## PAVEMENT DESIGN REPORT

**Copper Chase at Sterling Ranch, Filing No. 1  
Phase 2  
El Paso County, Colorado**

**JOB NO. 193596-2**

**June 4, 2024**

Figure No. 14

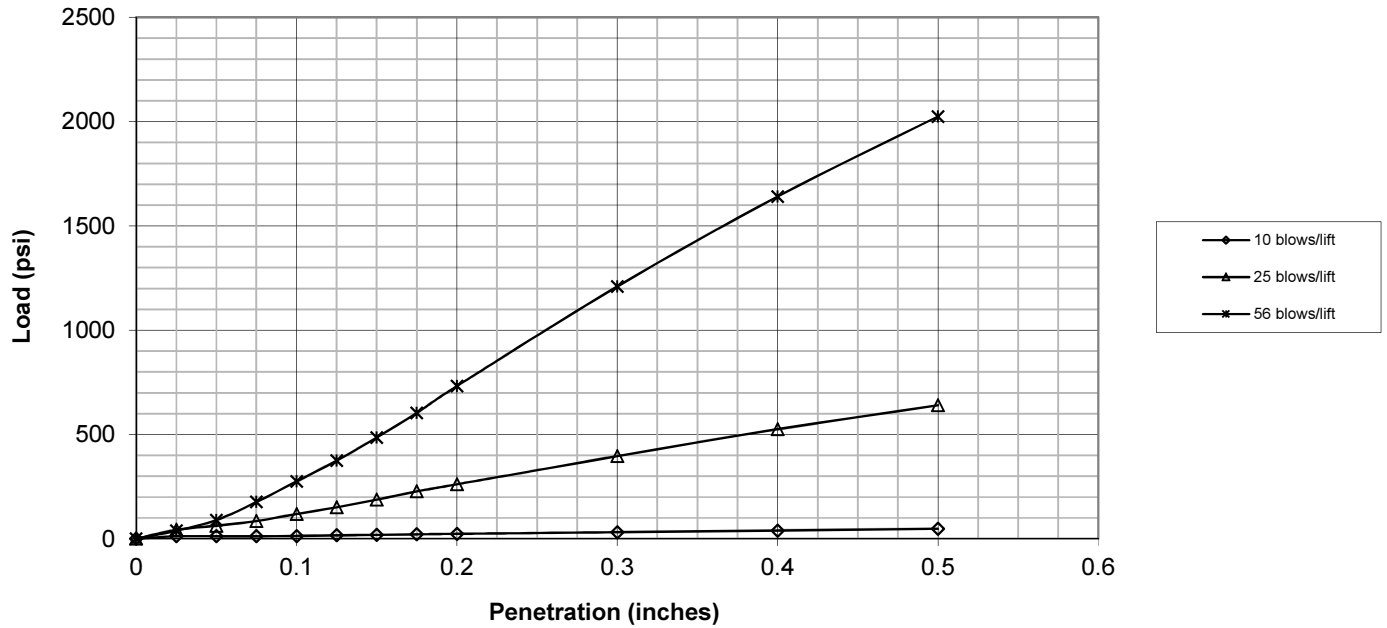
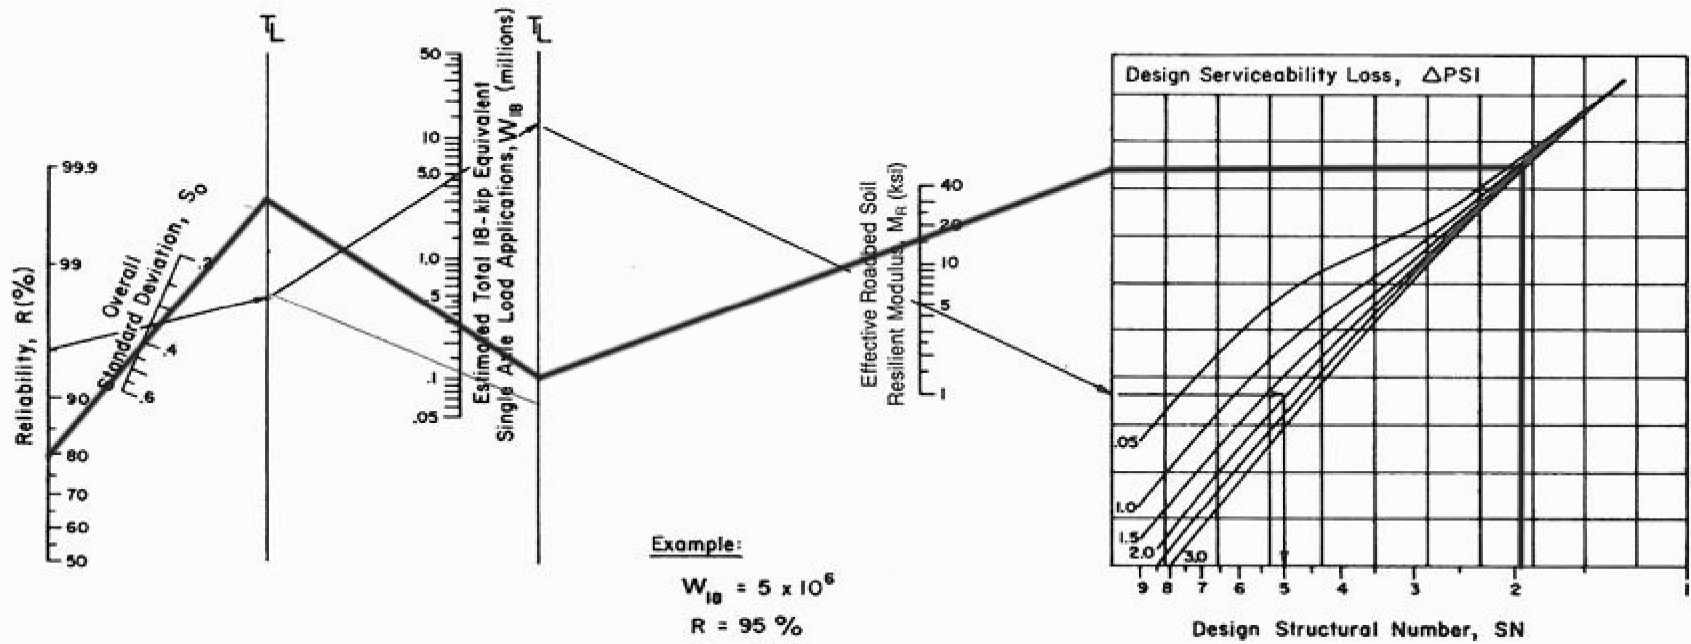
Figure 13 & 14 refer to the bulk sample A-7-6 soil from TB-6 and TB-8. Provide the test results for the bulk A-6 soil sample and include explanation for its inclusion in this report. The pavement was not designed based on the resulting CBR value here. A more robust section would be required for the CBR of 1.24.
